From: Zac Denton
Sent: 12 July 2019 15:43
To: Planning.Responses <Planning.Responses@arun.gov.uk>
Subject: FW: LY/4/19 - ADDITIONAL COMMENTS ON THE REVISED PLANS

ADDITIONAL LCOMMENTS ON THE REVISED PLANS

Drawing Title: PROPOSED ELEVATIONS

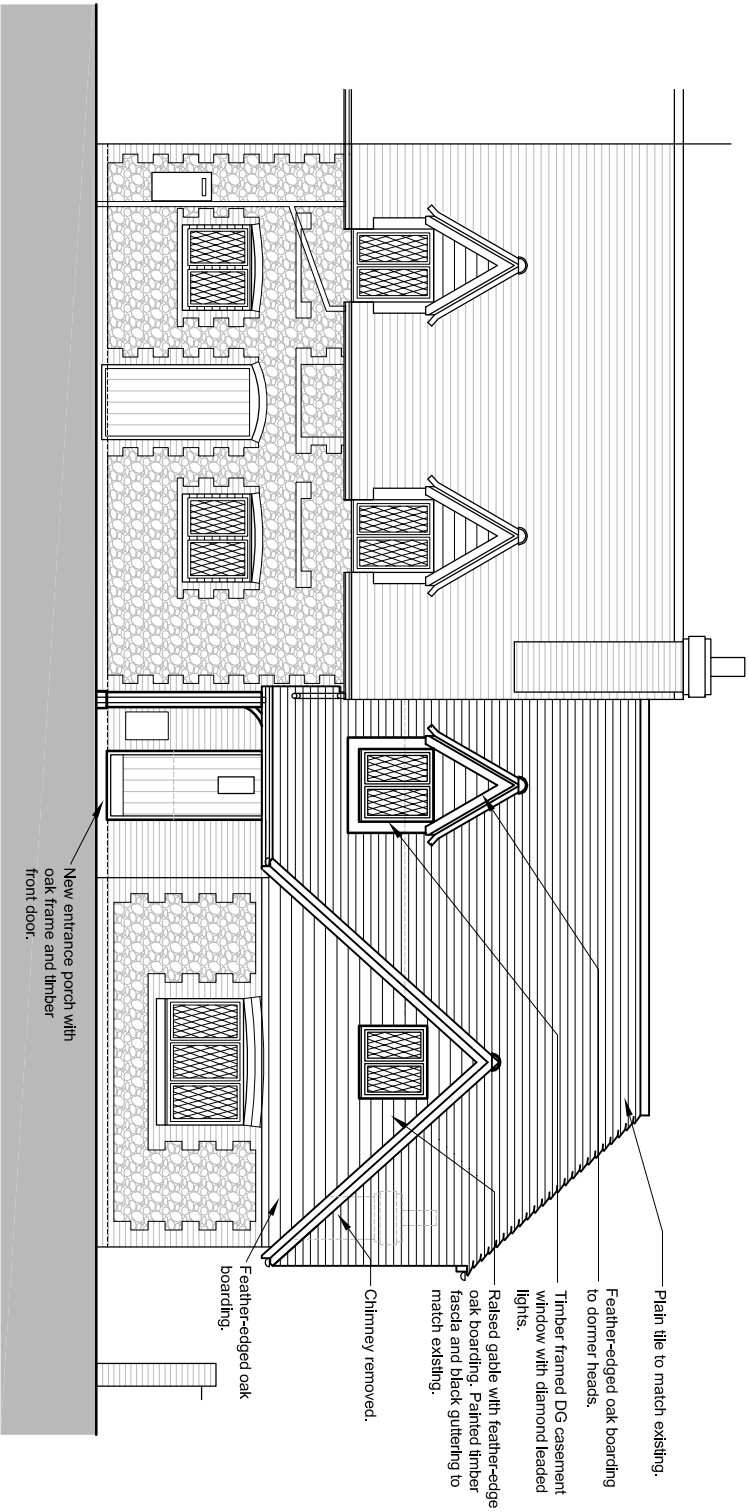
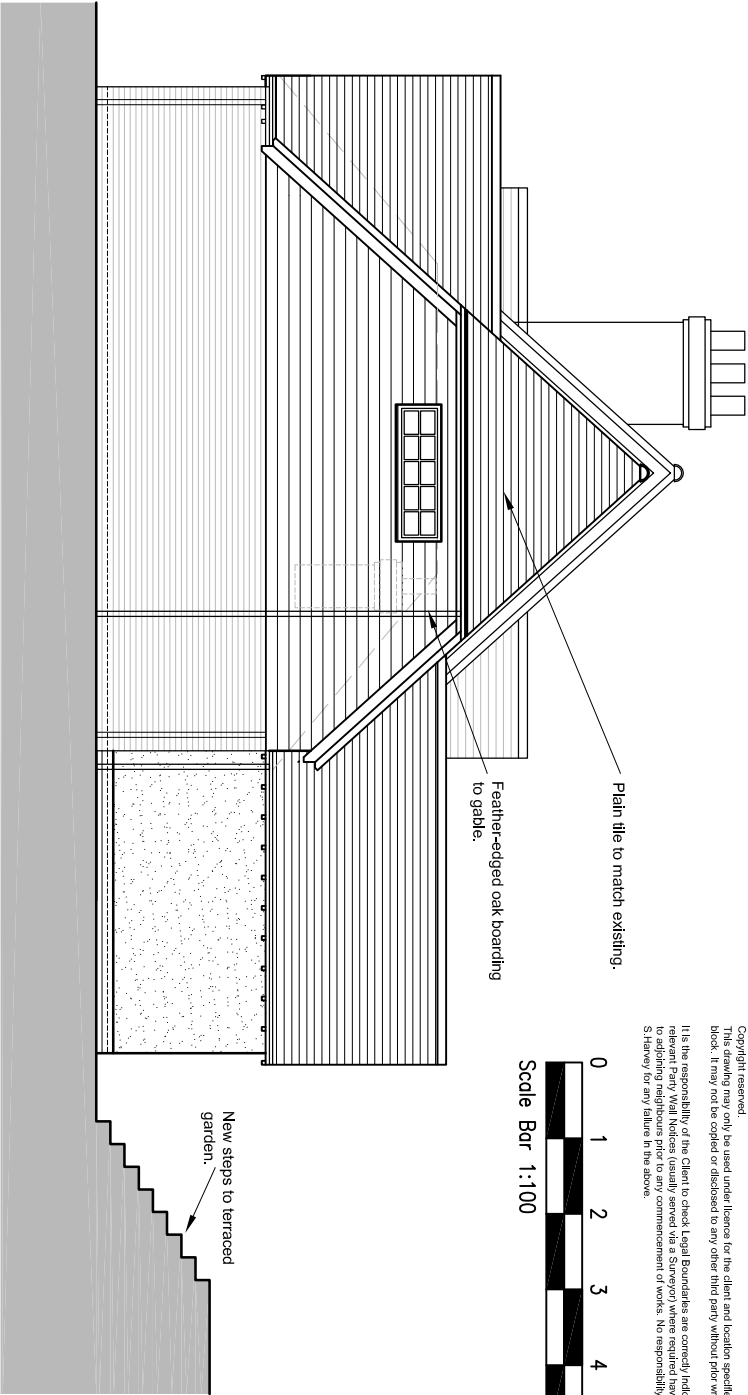
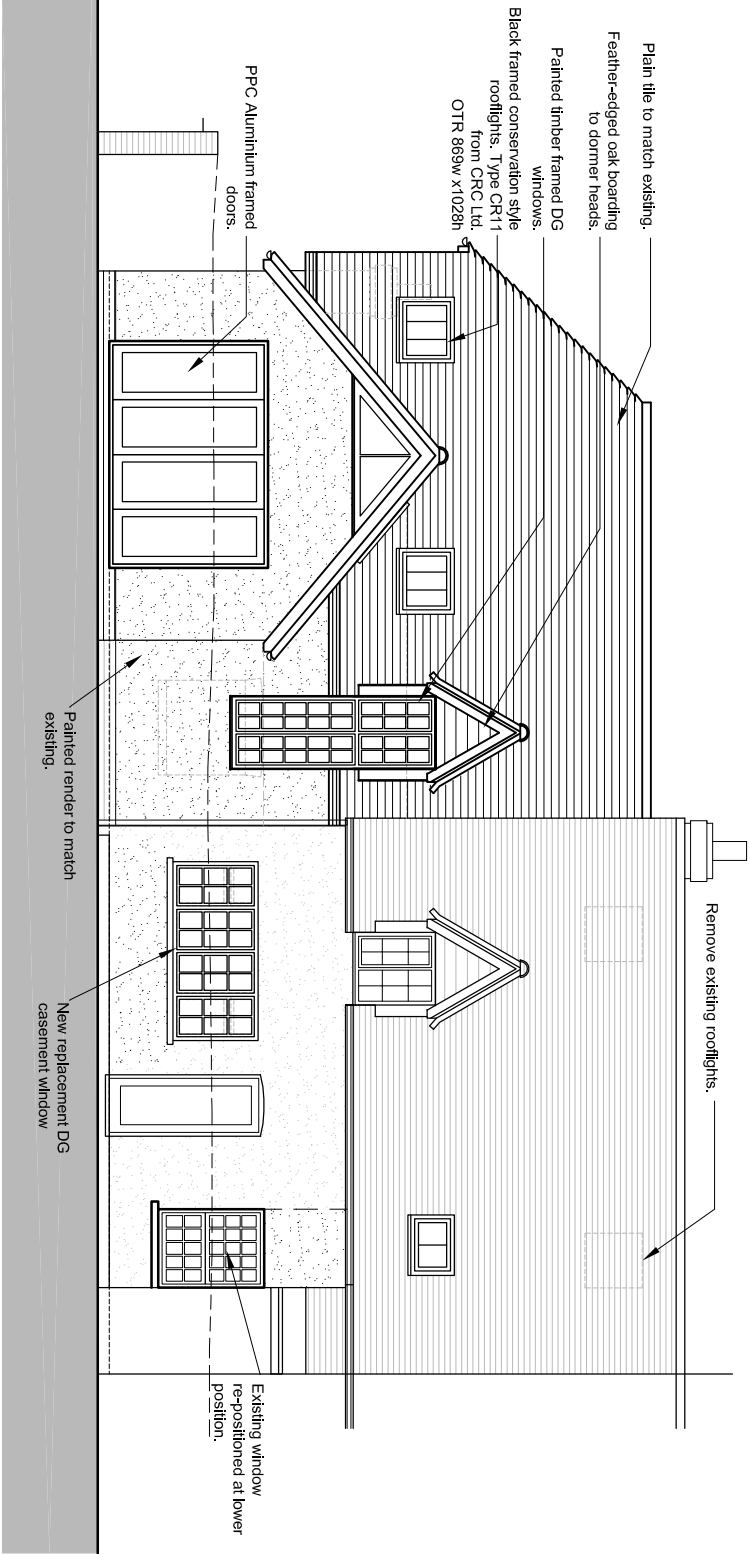
Having had the opportunity to review these new plans, it is considered that the revised scheme appears to take onboard the information and various points that I raised. The revised design reads as a more subservient extension to the host dwelling and, allows for the development of the building to be understood. Further, the retention of the existing chimney, as well as the use of a gabled elevation are positive enhancements to the scheme.

I should point out that the quality of the design and materials used will need to be high. For instance, the dormers, the new doors/windows and glazing should closely copy the existing features. Details of these will need to be provided for by way of condition.
